**Re: Juan Tabo Unit 3B Grading and Drainage Plan
Engineers Revised Stamp Date 4-14-14 (M-22/D016B)**

Re: Juan Tabo Hills Unit 3B
Engineer's Stamp Date 4-14-14 (M22D016B)
Certification dated 2-9-15

TYPICAL LOT LAYOUT PLAN - BLOCKS 1 & 3

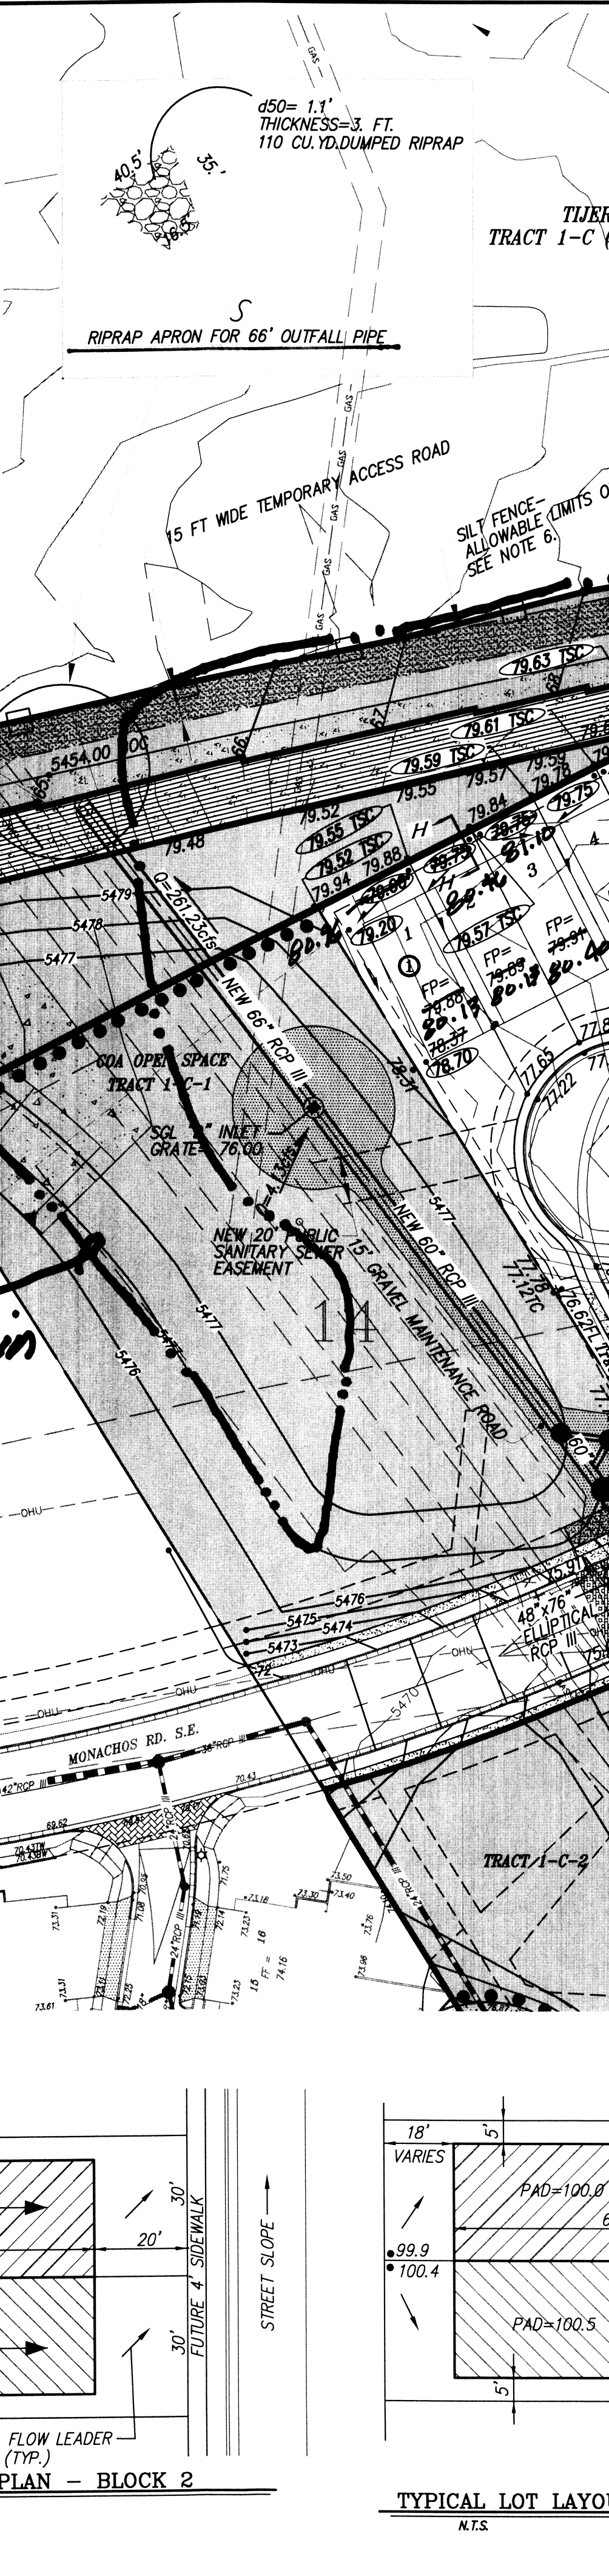
1. The grading of the site is acceptable; except for the swale between lots 3 and 4 is directed towards the electrical box and other dry utility boxes. Should a small wall be constructed upstream of the boxes?

1. When the home builder completes the townhome construction and does the fine grading, the swale will be directed around the box. I visited the site and I know the grading looks rather dramatic right now but it will be smoothed out when the home is completed.
